20251022-ACP-323018

Ref: 323018
App: Gort Windfarms Limited
For: Development pursuant to Section 37L of the Planning and Development Act 2000 (as amended) The development consists of the Decommissioning of Derrybrien Wind Farm (Site 132 HA) including enabling works; the removal of the turbines and other structures on site; the removal of the Derrybrien-Agannygal overhead line; and all other works. A remedial Environmental Impact Assessment Report (rEIAR) and a remedial Natura Impact Statement (rNIS) was submitted with the application.
Site: Bohaboy, Boleyneendorrish, Coppanagh, Derrybrien East, Derrybrien North, Derrybrien South, Derrybrien West, Funshadaun, Kilbeg, Loughatorick North, Toormacnevin in Co. Galway & Slieveanore, Co. Clare

20251022-ACP-323014

Ref: 323014
App: Gort Windfarms Limited
For: Substitute Consent pursuant of Section 177E of the Planning and Development Act 2000 (as amended) in relation to the Decommissioning of Derrybrien Wind Farm. The development consists of the proposed retention in situ of existing development associated with the Derrybrien Wind Farm Development (Site 458 Ha) including all at and below ground structures. A remedial Environmental Impact

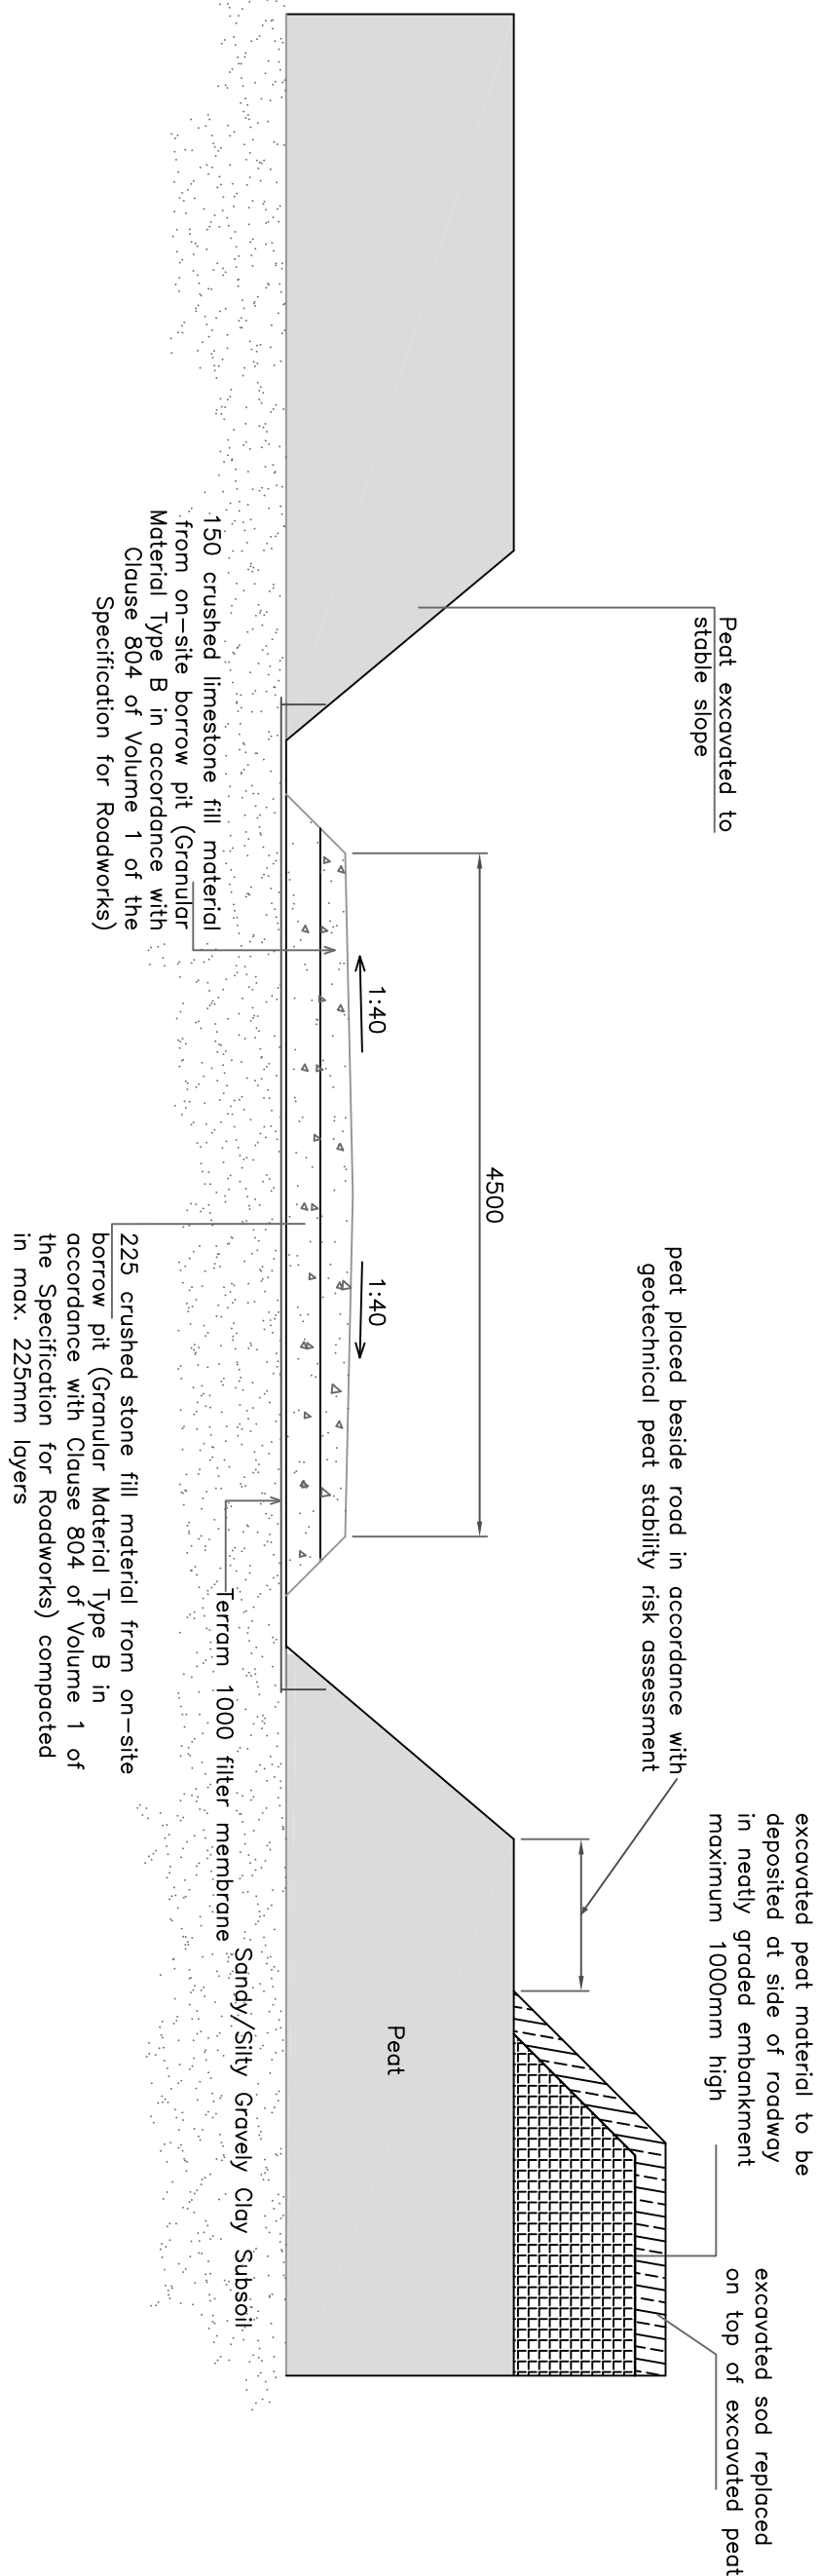
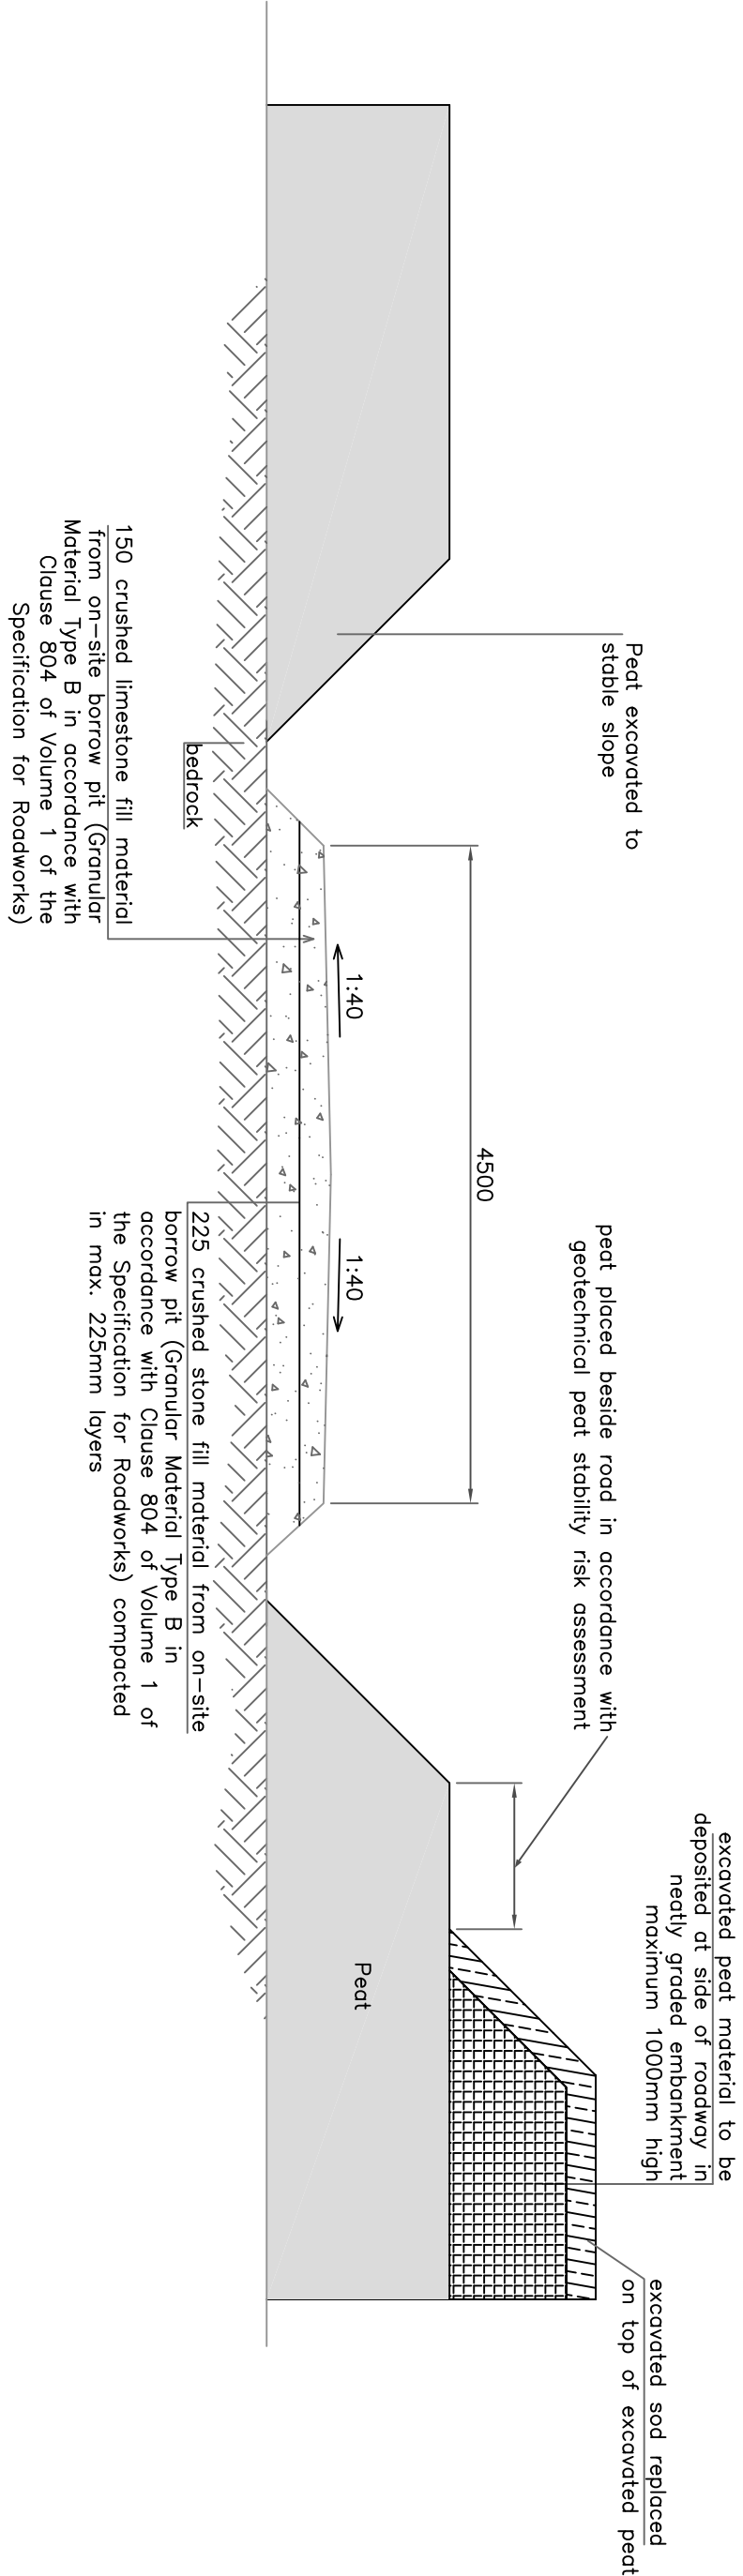
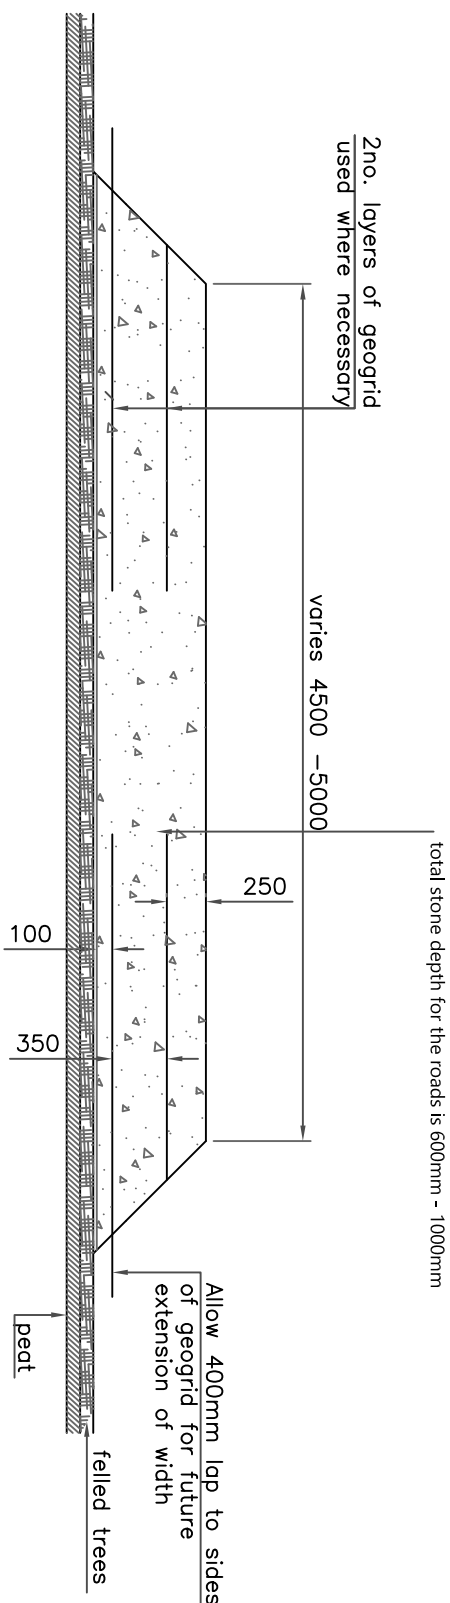
It needs to be ensured that existing access roads are sufficiently robust to accommodate cranes and increased Heavy Goods Vehicle (HGV) movements required to carry out decommissioning works. The potential risks and impacts of these increased movements and additional weight, including to peat stability in the immediate vicinity of these roads, should be fully assessed. The timing of the works

and the machinery movements also needs to be considered in light of rainfall, the risk of storms, etc. If granted, conditions should be applied accordingly to restrict movements before, during, and following rainfall events.
